OXFORDSHIRE COUNTY COUNCIL'S RESPONSE TO CONSULTATION ON THE FOLLOWING DEVELOPMENT PROPOSAL

Application no: 21/01630/OUT

Proposal: Outline planning application for residential development (within Use Class C3), open space provision, access, drainage and all associated works and operations including but not limited to demolition, earthworks, and engineering operations, with the details of appearance, landscaping, layout and scale reserved for later determination

Transport Schedule

DRAWING TITLE  
**CONSTRUCTION ACCESS  
OVERVIEW PLAN**

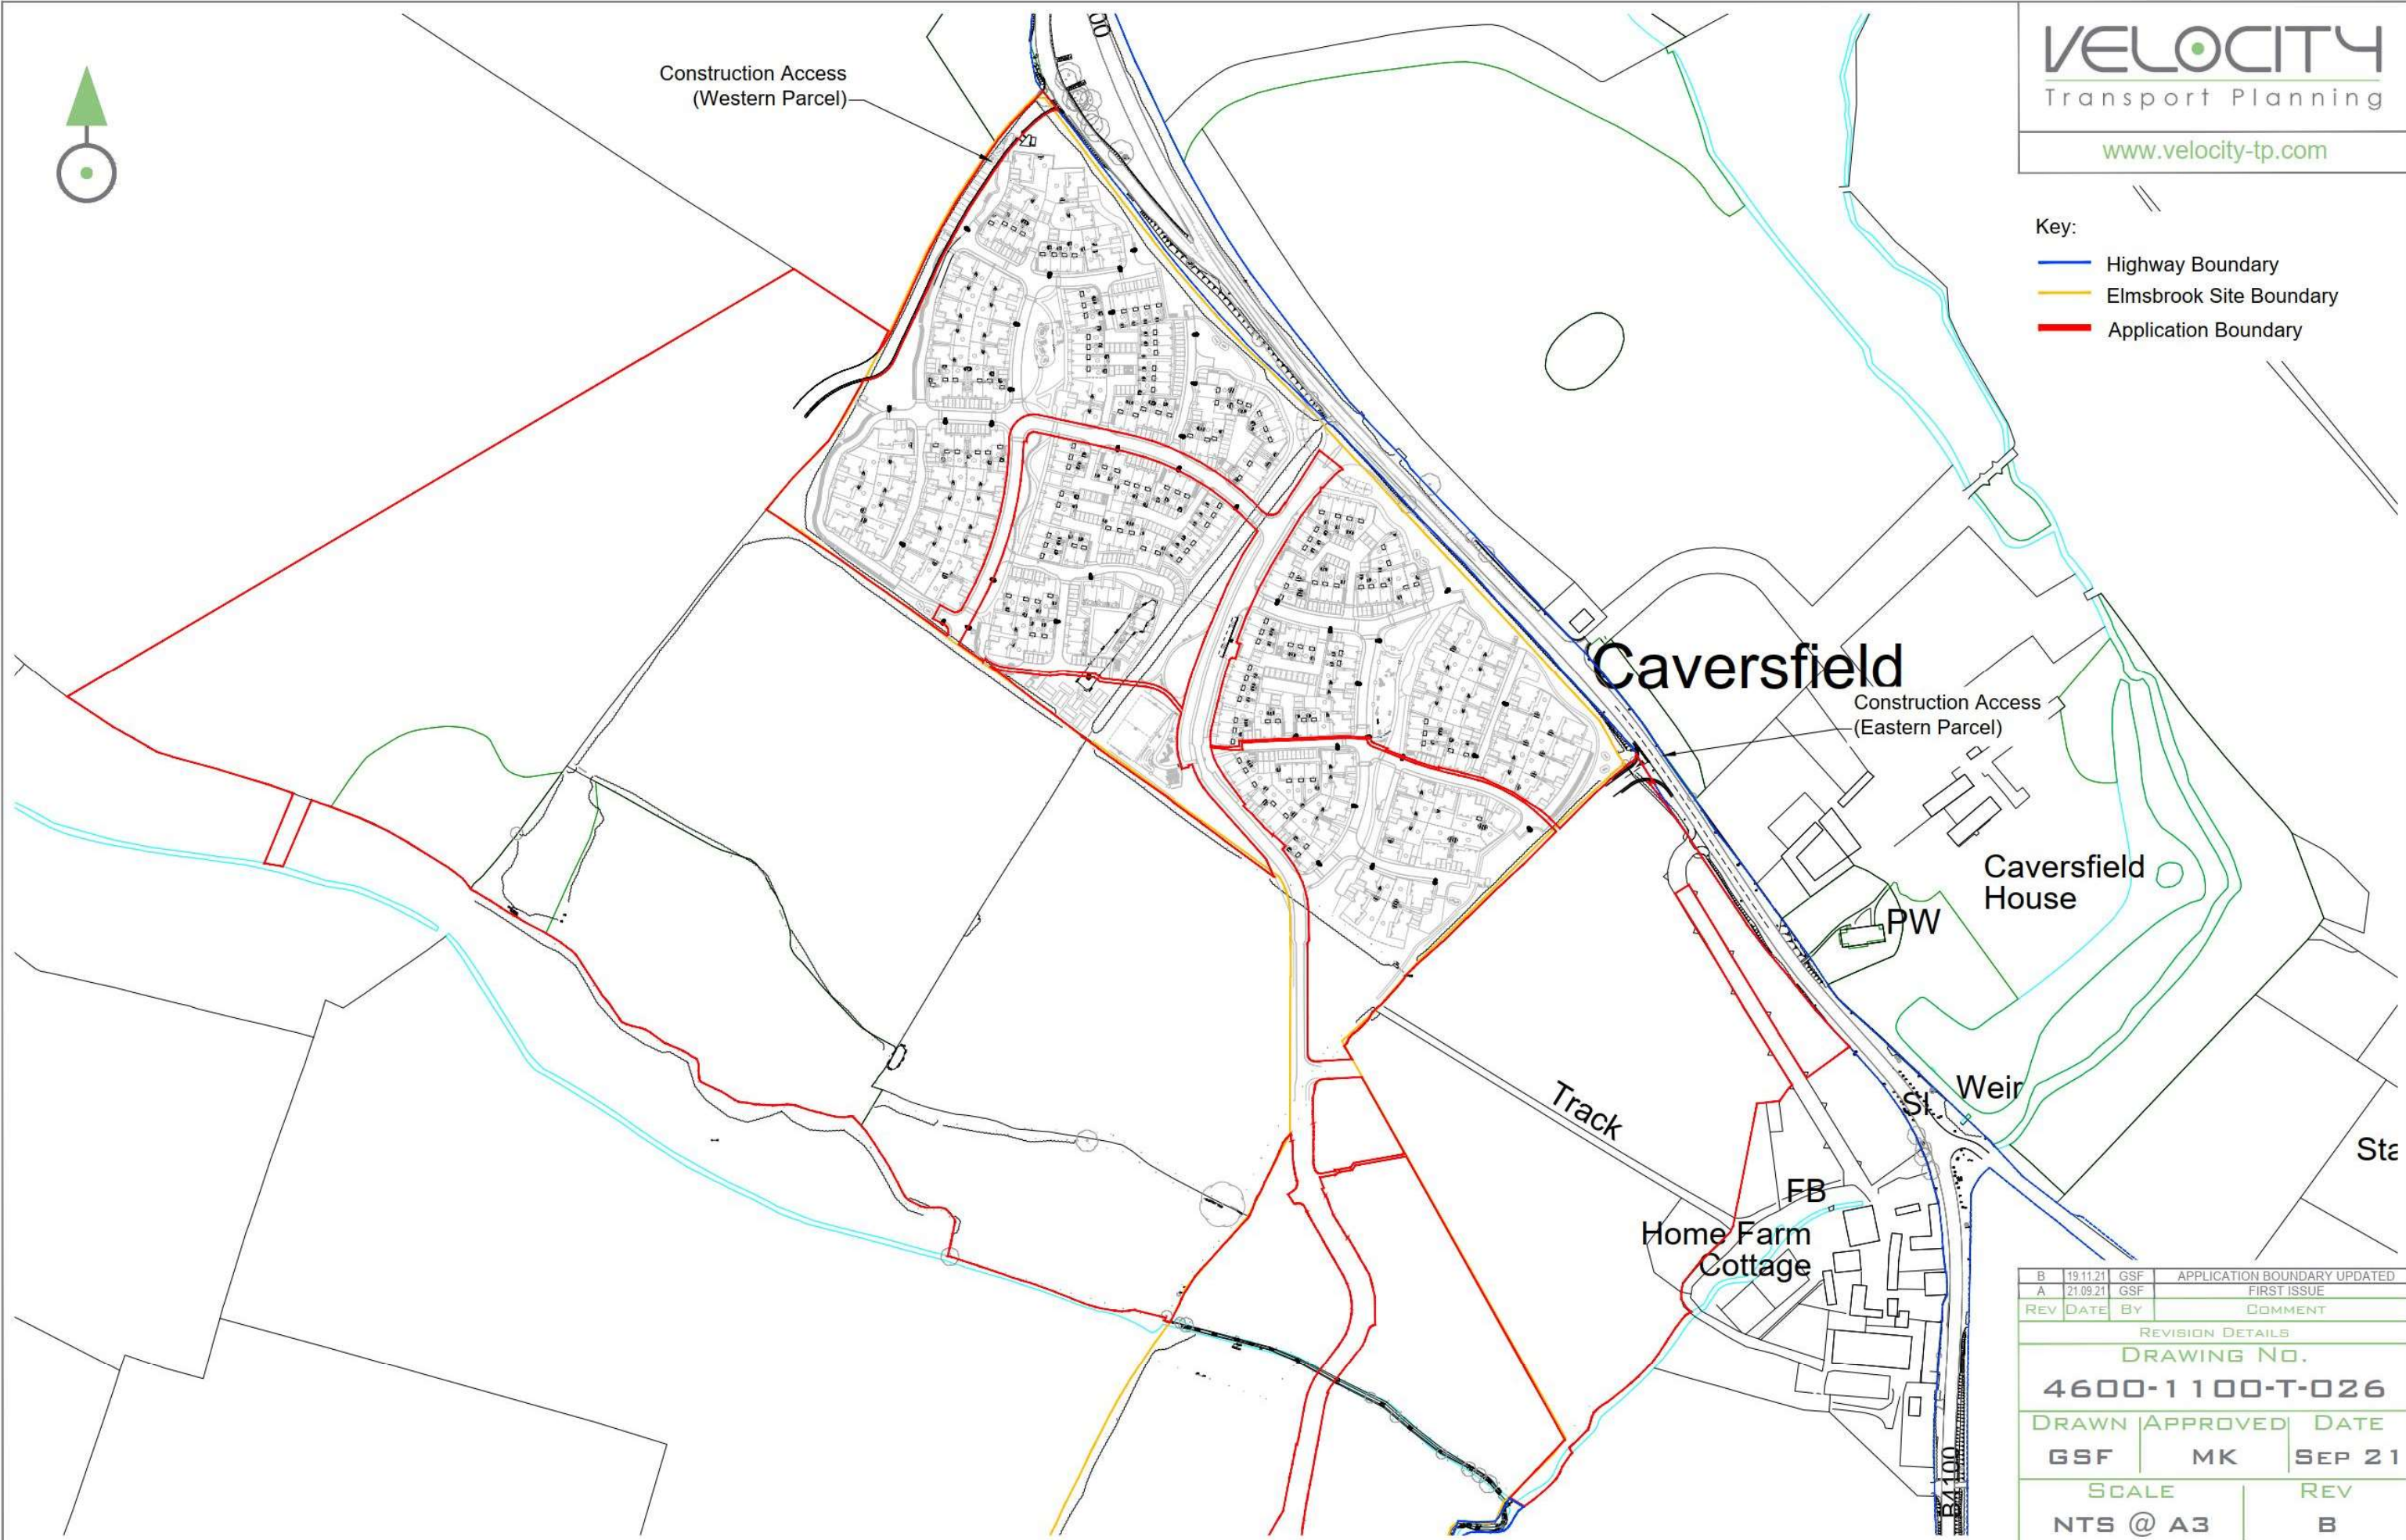
- An alternative construction access to the western parcel is proposed via the existing layby on the B4100. This is welcomed as an alternative to a construction route through residential streets, although substantial works and traffic regulation orders will be required to make it acceptable, and a S278 agreement with OCC will be required to carry out the works, as well as Land Drainage consent to culvert a ditch.

visibility splay crosses non highway ditch that is not within red line	visibility splay of 90m to a position 2m away from the kerb-line, which is achievable without crossing the non-highway ditch.	speed restriction to 30mph in the vicinity of the access.	
8	Construction access to western parcel – access through residential parcel not suitable. Swept path for max artic required for access C.	Alternative access proposed off layby on B4100, and along western edge of Exemplar site Phase 4	This is a better alternative than taking a route through Elmsbrook roads. However in order to operate safely and without obstruction, a considerable amount of parking would need to be removed from the layby, which would need to be achieved through a TRO. CDC will need to consider any impact on recycling facilities and hot food pitch. The layby is in poor condition, and, while sufficing as a layby, if it is to become part of a haul route it will require improvement by the developer prior to use. There is a large ditch that would require to be culverted. An appropriate design of sufficient capacity would need to be approved by the adjacent riparian landowner and CDC as Land Drainage Authority. Access to the adjacent public right of way that leads from the layby should be facilitated and improved. A TRO would also be required to ban right turns into the layby, and additional warning signs would be required. Further details should be required by condition and the arrangements should be	Partially

complete prior to commencement. A S278 agreement will be required with OCC as Highway Authority prior to any works being carried out on the highway, and a contribution will be required to cover the cost of consultation and implementation of TROs.	
9	Walking distances to facilities are not accurate	The map and table showing walking distances have been corrected.	This demonstrates that in isolation the site has little potential for walking as a modal choice, making improvements to cycling routes even more important. The applicant has not objected to making the requested proportionate contribution to improving cycle infrastructure in accordance with the Bicester LCWIP.	Yes
10	No commitment to provide a pedestrian crossing of the B4100 to Caversfield Church	A signalised crossing and linking footway would be provided as part of the S278 works for the proposed development.	The design shown is in line with one agreed in relation to a previous planning application at the site	Yes
